Subject: FW: WA/21/21/DOC - Wandleys Farm Condition 3 Materials

Subject: WA/21/21/DOC - Wandleys Farm Condition 3 Materials

The above application does not contain any eaves detail as required by the condition. If these are not provided within the next 7 days the application will be determined as submitted.

A	MINOR AMENDMENTS	09.03.2
REV	DESCRIPTION	DATE
PROJECT LOW COST HOUSING UNITS WANDLEYS FARM WANDLEYS LANE FONTWELL		
CLIENT MR & MRS K LILLYWHITE		
DRAWING TITLE CONSTRUCTION DETAILS SHEET 1 OF 2		
SCALE	DRAWN BY	DATE
1:5 @ A1	TP	JAN 21
DWG NO	944/BRO7	REV. A

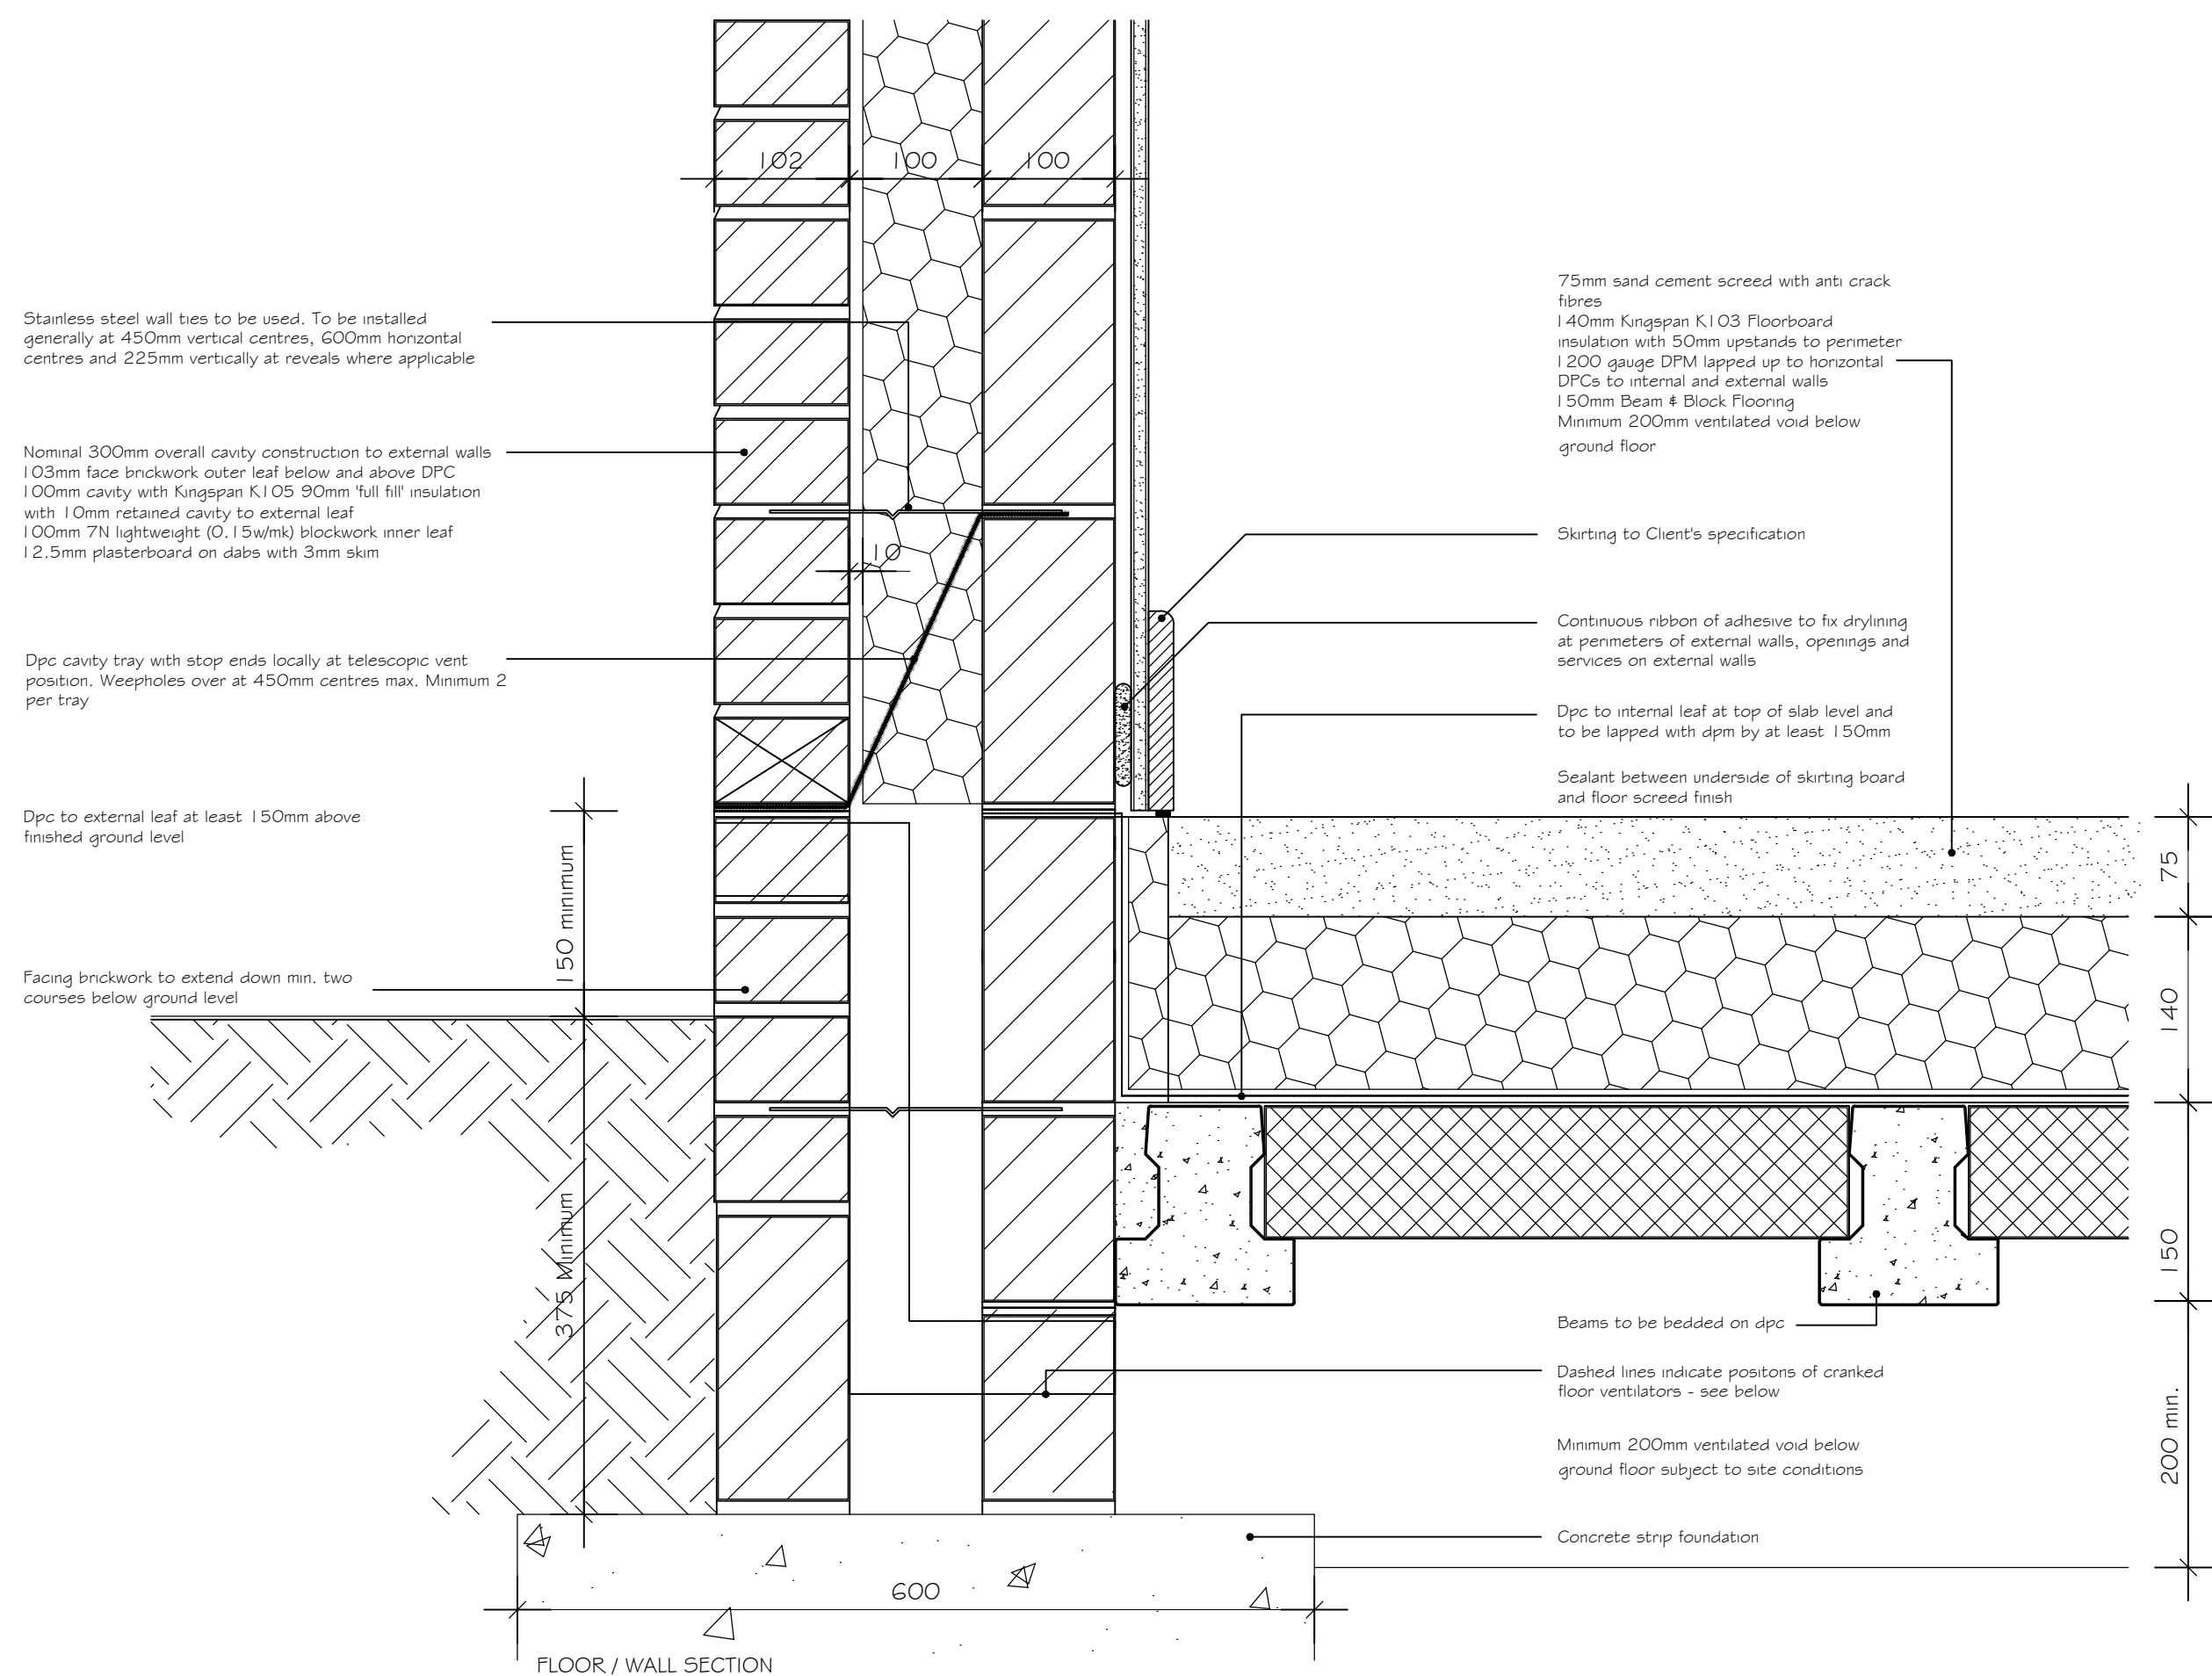
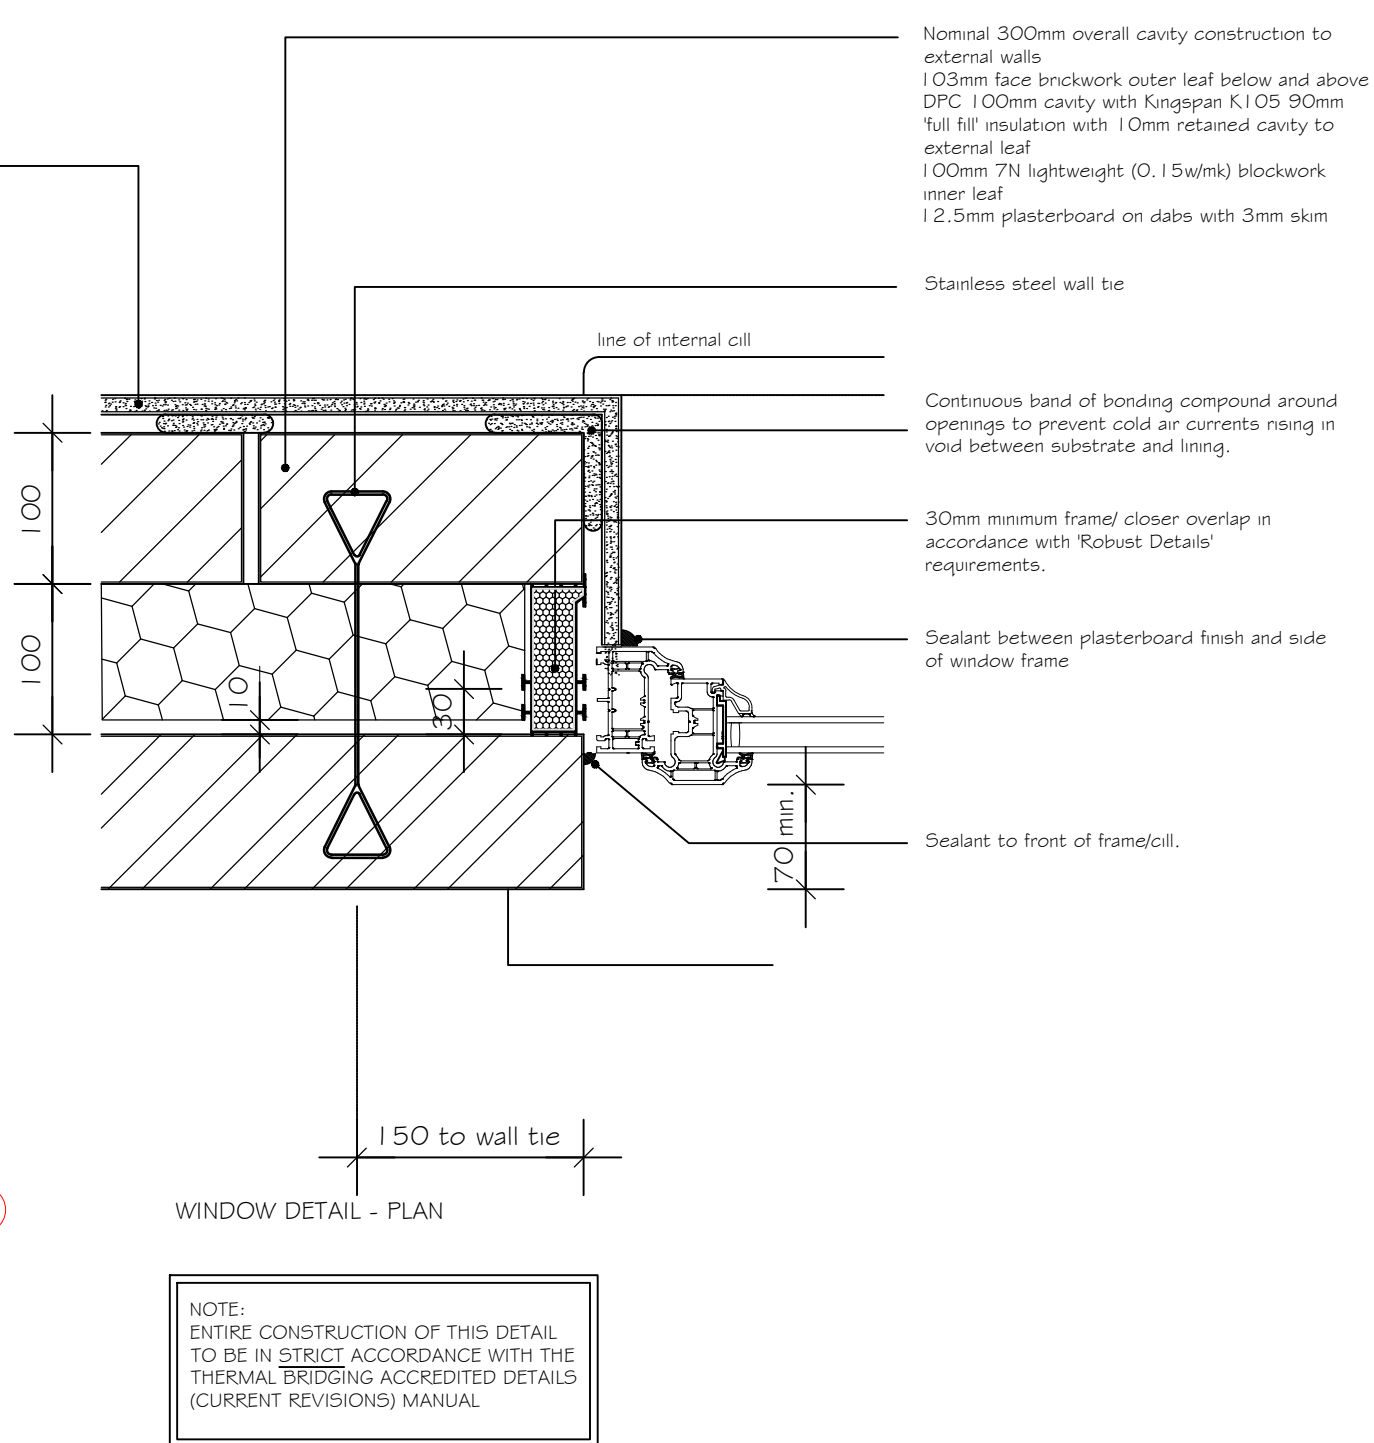
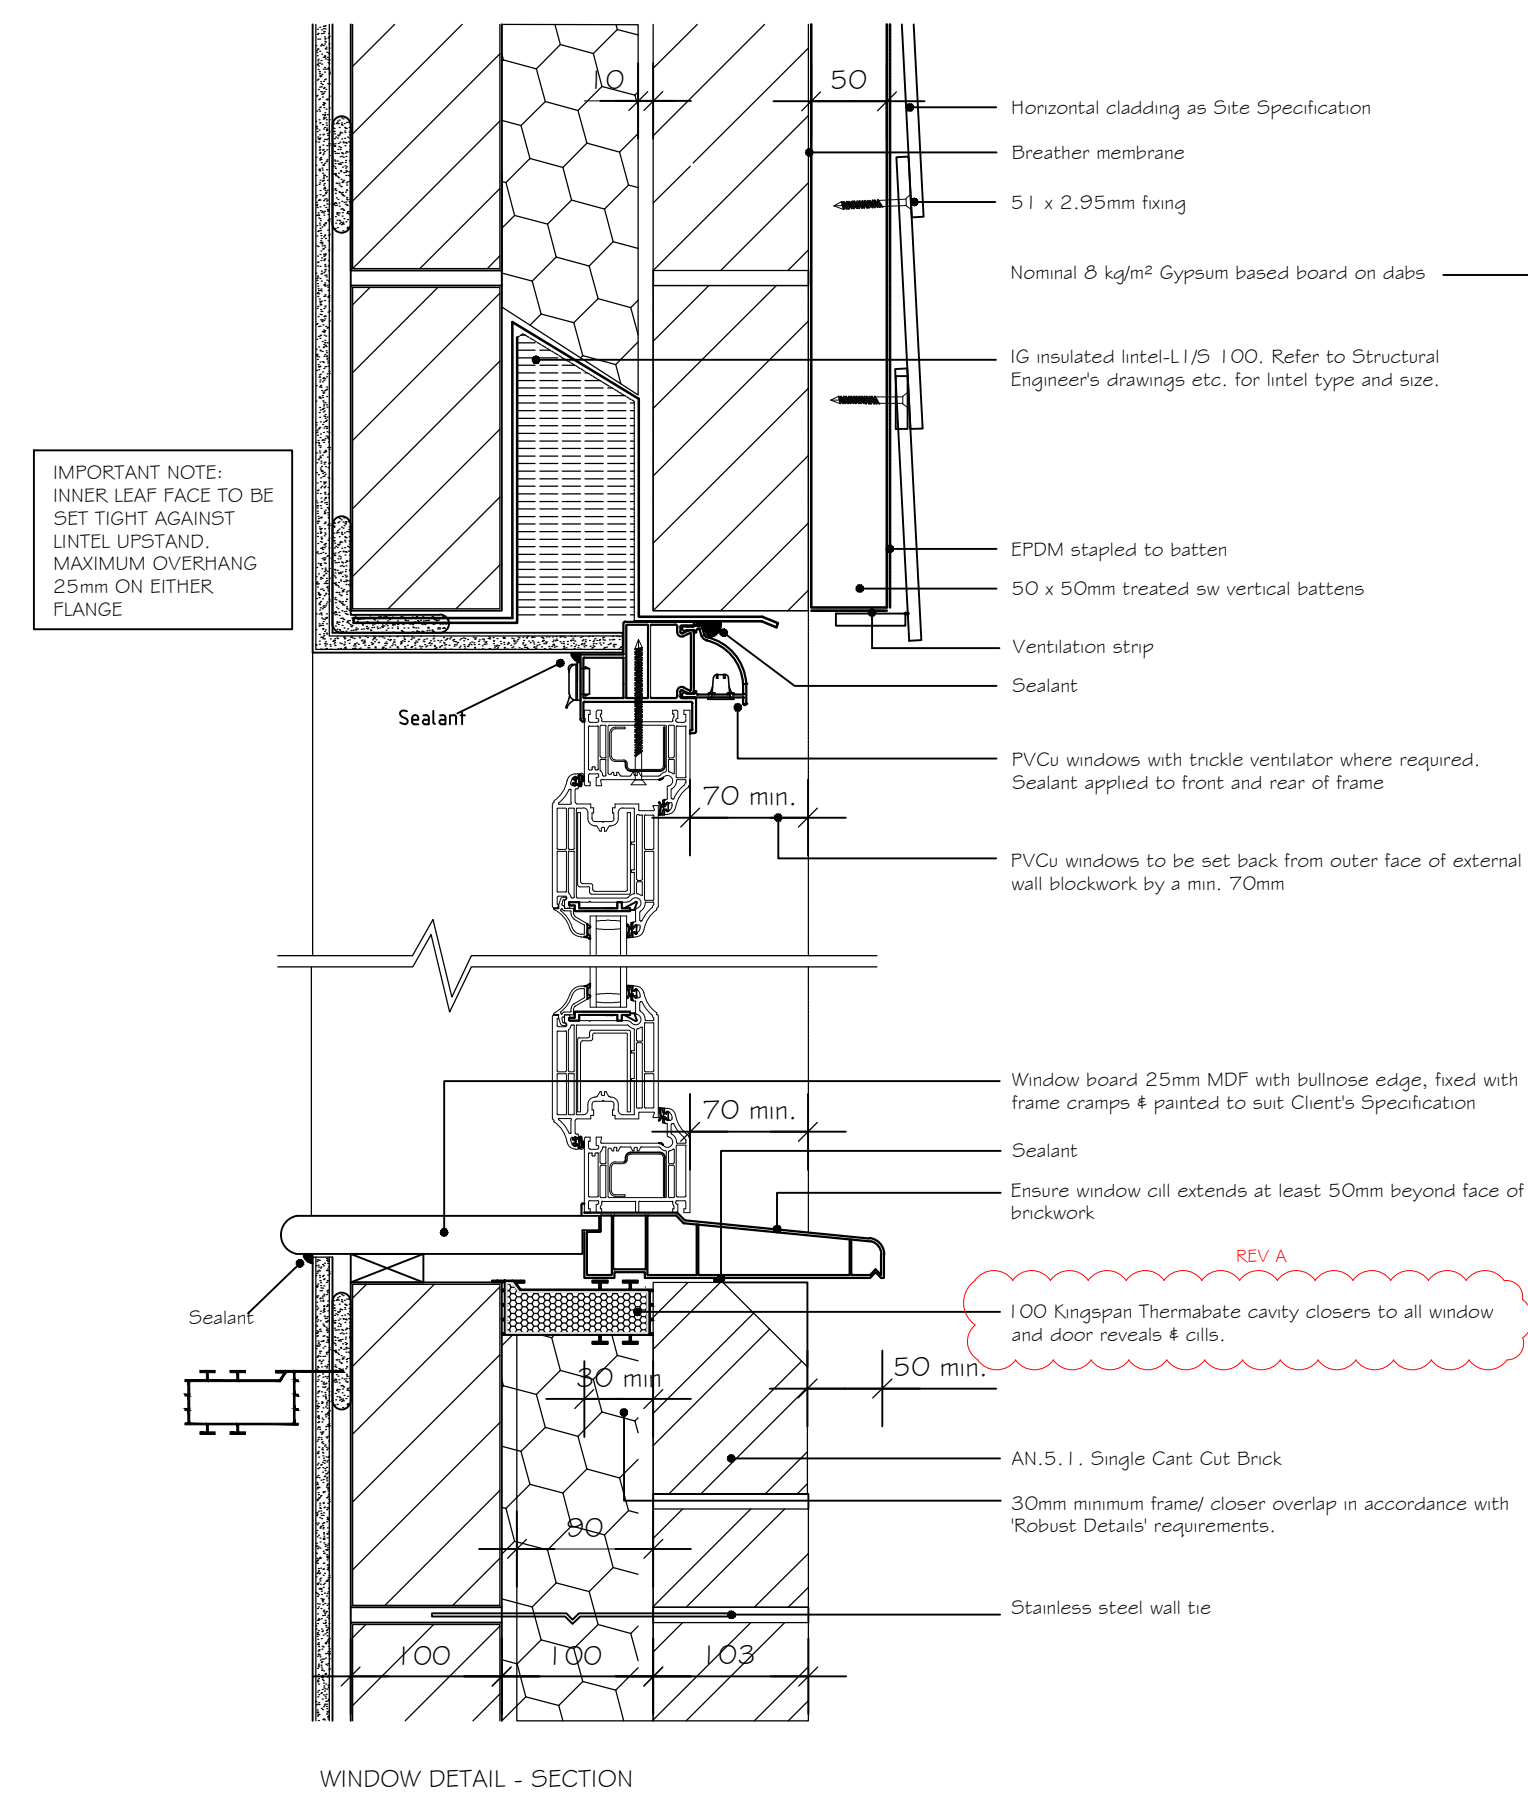
Further the use of white PVCu or powder coated aluminium units to the dwellings is not appropriate in this rural location. Oak effect woodgrain UPVC is suggested as was indicated on the original application. Please can you reconsider the materials for windows and doors of all units. In addition I note that no details of tile hanging for the detached house or materials for the garage have been submitted.
